Re: DSR23-006 SUB3 Response Letter: 3003 77th Ave SE, Mercer Island, WA 98040

Planning Comment:

Tree:

C2.10

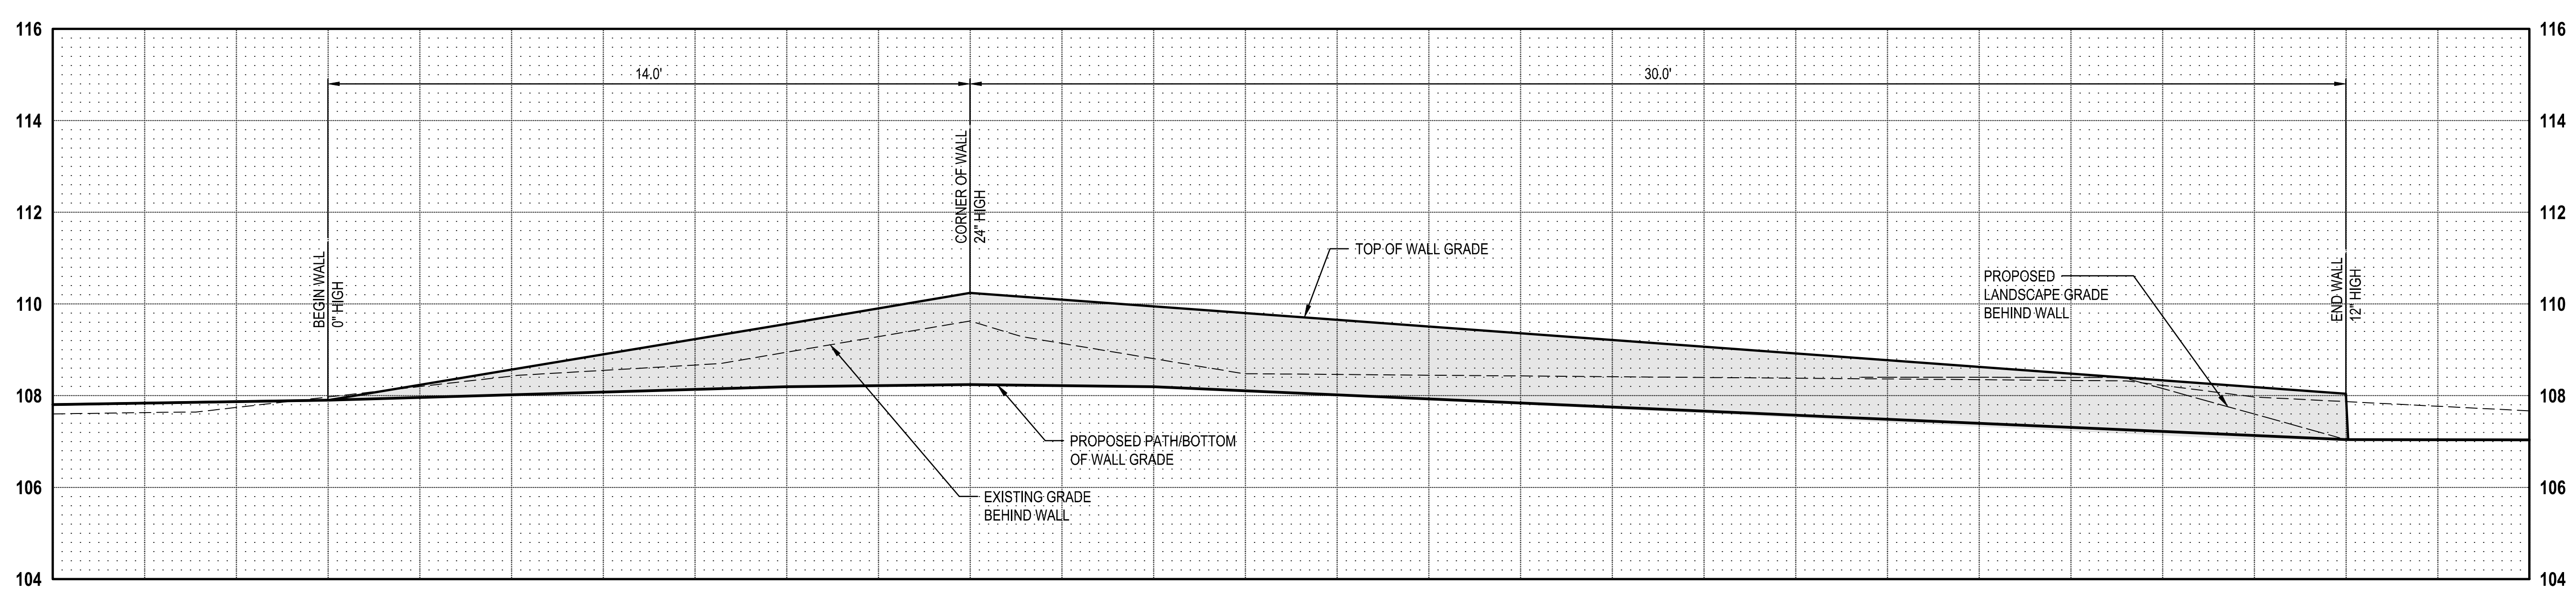
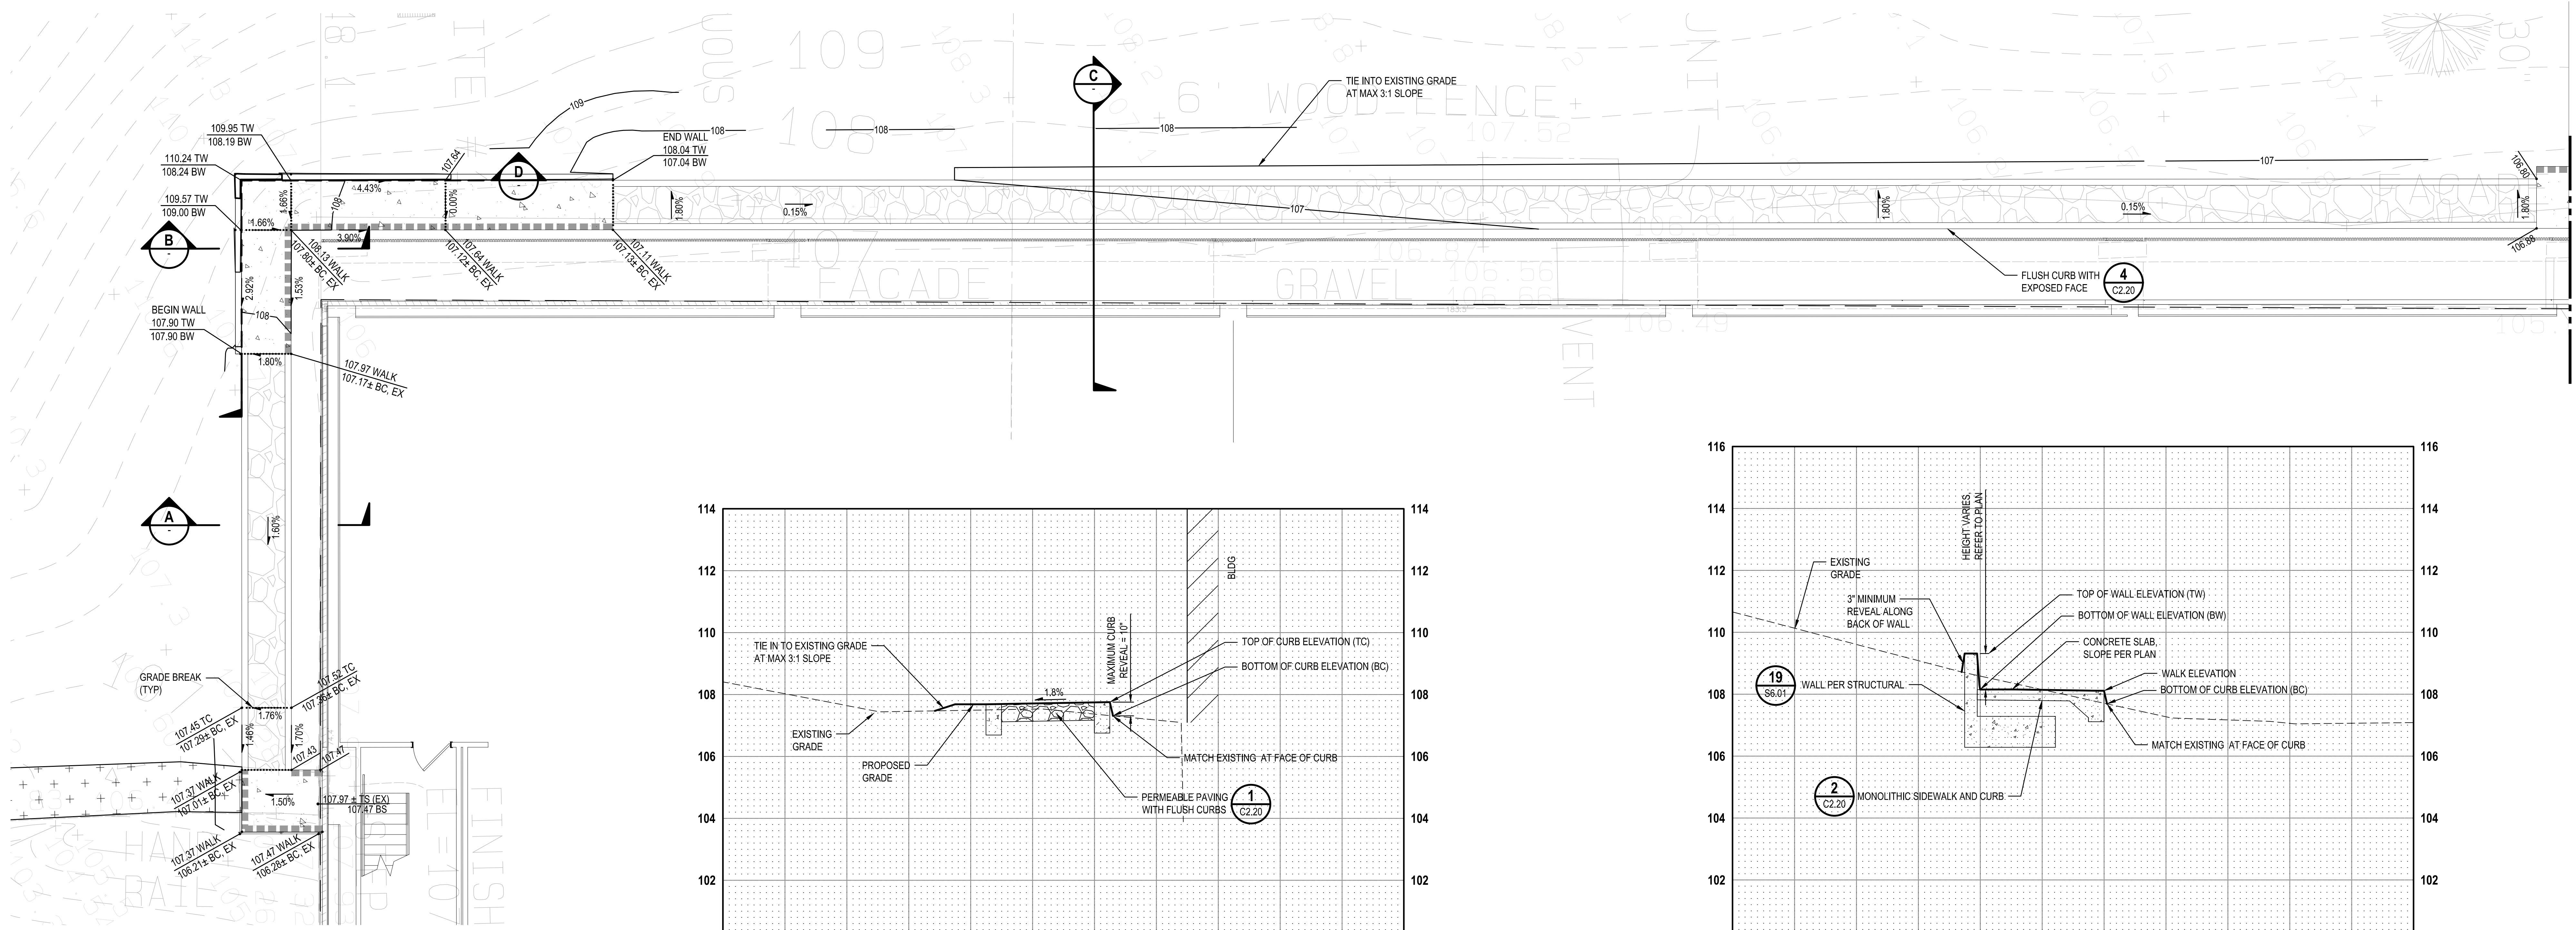
1. Remove grading note within park property on C2.10, as called out in the arborist memo. ***[Response] The Sheet C2.10 has been updated. See attached email correspondence about the grading comments.***

2. Add the following note from the City Parks Memo: a. No pruning, excavation, grading, or root pruning is approved for this work. Parks staff will prune branches on the western red cedar located at the west portion of the area to allow for vehicle passage. ***[Response] Sheet C2.10 has been updated with additional notes.***
